Your Ref: MP05_0129

5 December 2012

**Preferred Project Report, Lakes Estate Residential Subdivision, North Boambee Road,
North Boambee Valley (MP05_0129)**

DRAWING TITLE  
SUBDIVISION STAGING PLAN

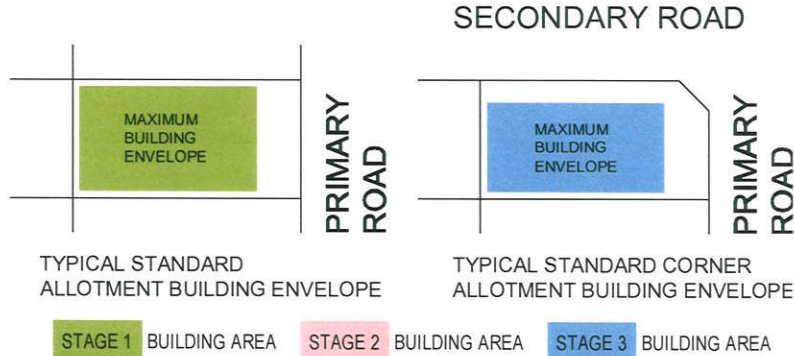
- a staging plan showing the location of APZs (temporary) between stages and provision of satisfactory access for each stage;
- reference to AS 3959-2009 which supersedes AS 3959-1999;

DRAWING TITLE  
SUBDIVISION STAGE 3 PLAN  
LOTS 116-140, LOT AND PART LOT 141 (RESIDUAL)

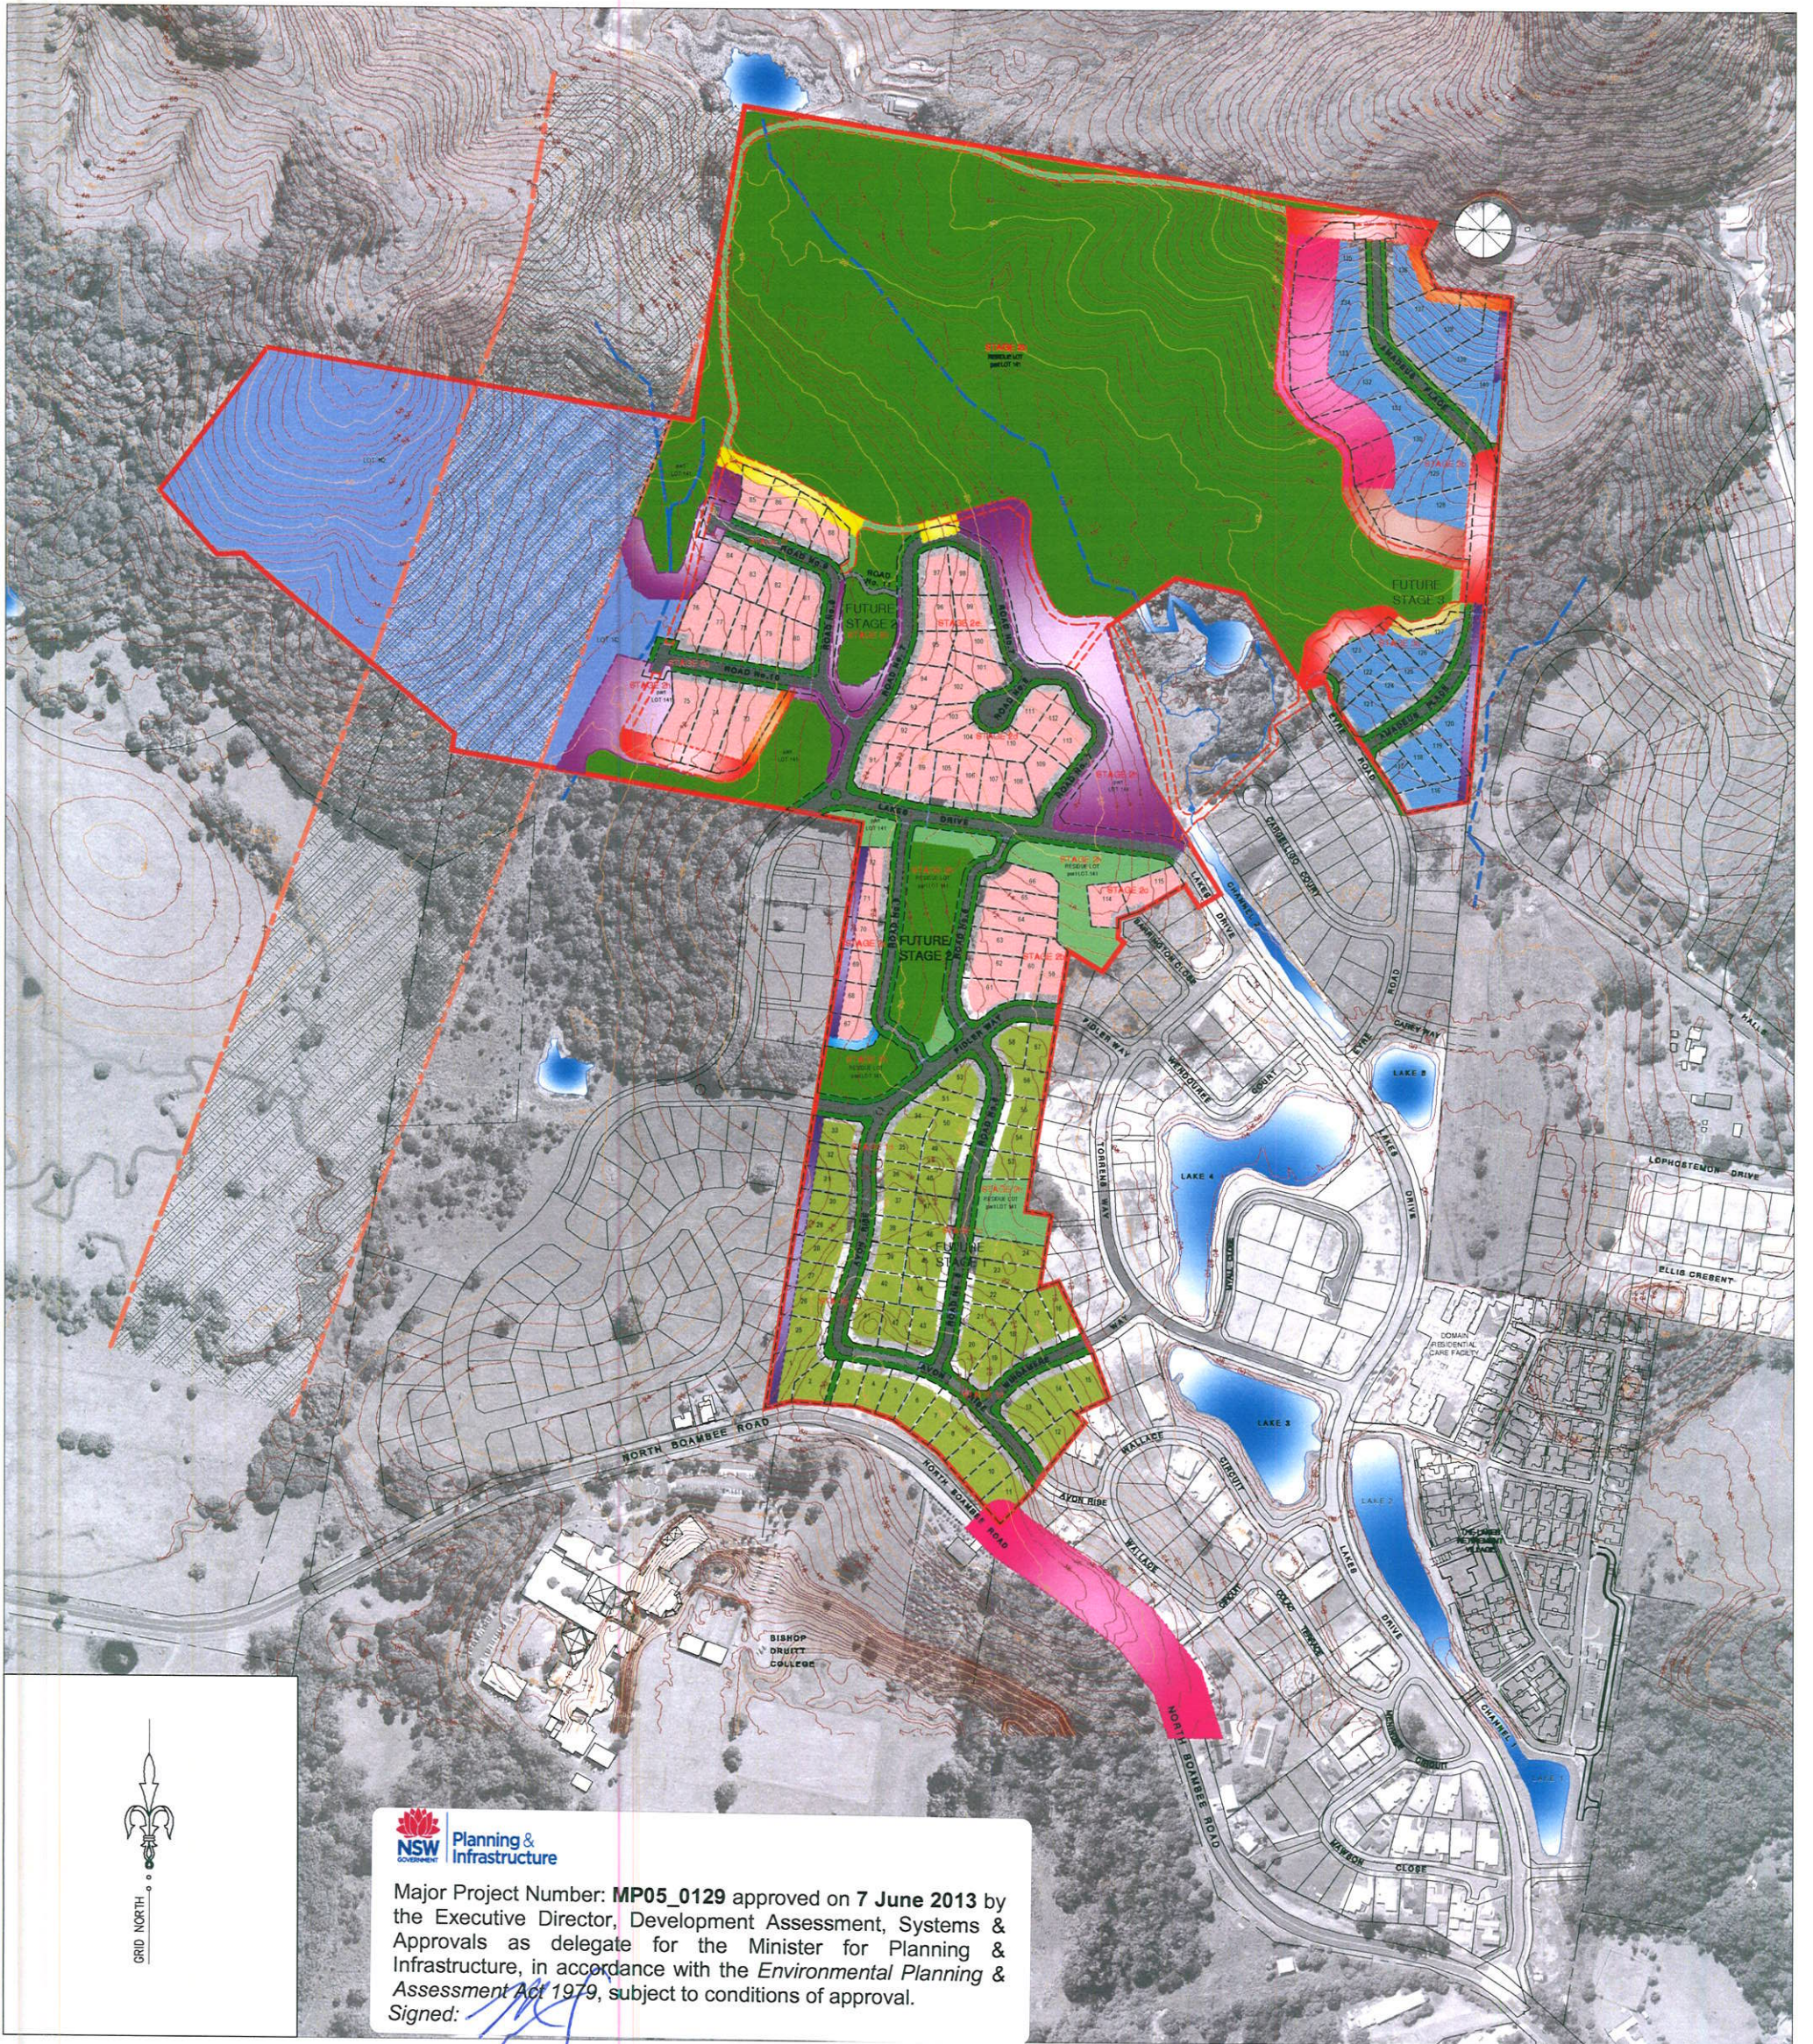
- plans of proposed APZs showing the full width (dimensioned) and location of proposed APZs;
- the proposed road layout, particularly for Stages 2f, 2g, 3a and 3b, does not meet the requirements of section 4.1.3 of 'Planning for Bushfire Protection 2006' and does not provide justification or demonstrate a clear benefit for the use of fire trails instead of perimeter roads;

- clarification of the following proposed fire trails:
 - east of Stage 2d – the proposed fire trail traverses adjoining land; and
 - north of Stage 3b – will this link to Kratz Dr via Roberts Hill Reservoir and is legal access available over this land;
